## PLANNING CONSULTATION RESPONSE

<b>Application No</b>	2025/0942
<b>Proposal</b>	Change of use of land to commercial car sales including the relocation of existing security fencing to new site boundary.
<b>Address</b>	M D Car Sales, Wombwell Lane, Stairfoot, Barnsley, S70 3NT
<b>Date of Consultation Reply</b>	19/11/2025
<b>Consultee</b>	Claire Wilson, Planning Ecologist

**Figure 12** T1.

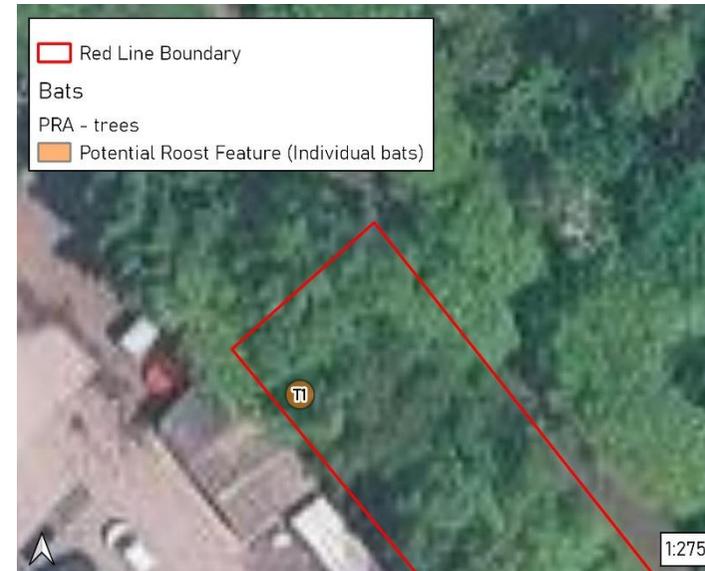
Site clearance activities have the potential to injury and/or kill small mammals and nesting birds, if undertaken in the absence of mitigation. A single tree was identified as having potential to support small numbers of roosting bats, therefore soft felling of the feature will be required during site clearance. A Precautionary Working Method Statement should be prepared to ensure habitats are cleared sensitively, this can be conditioned.

- At least two bat and bird boxes to be installed in suitable locations within the new building, or at a suitable location on site,
- A sensitive lighting scheme; and
- A Precautionary Working Method Statement (PWMS) to ensure habitats on site are cleared sensitively to avoid impacts to small mammals, birds and bats.
